# CITY OF PORTLAND BUILDING PERMIT

939 Congress St

PERMIT ID: 2013-00762    ISSUE DATE: 05/07/2013    CBL: 065 C001001

has permission to **replace 7 awnings - 3 in rear (one with 3.1 sf of signage) & 4 in front - all with signage (8 sf total)**

939 CONGRESS. SIGNAGE

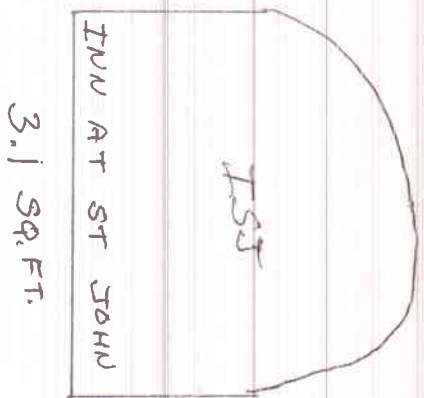
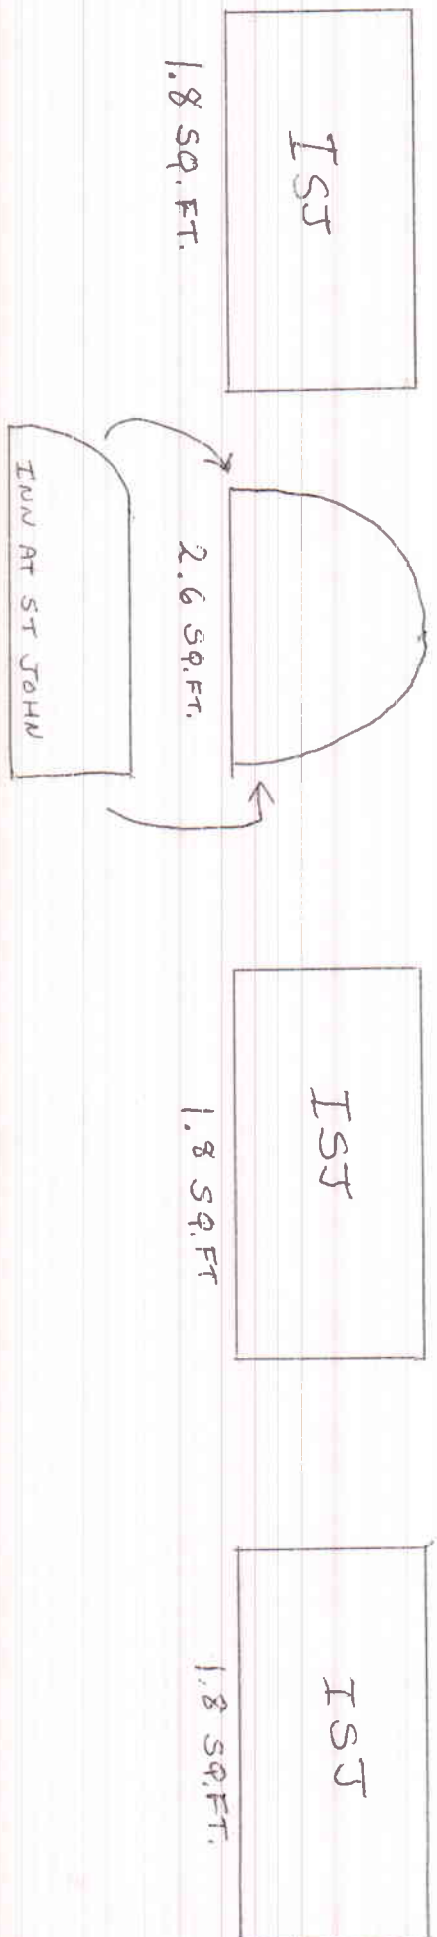
- 1) Encroachments into public ways must be a minimum of 8' above grade for signs and 7' for awnings per section 3202 of IBC 2009.
- 2) Signage and Awning Installation to comply with Chapters 16 (Structural Loads), 31 (Materials) & 32 (ROW Height & Encroachments) of the IBC 2009 building code.
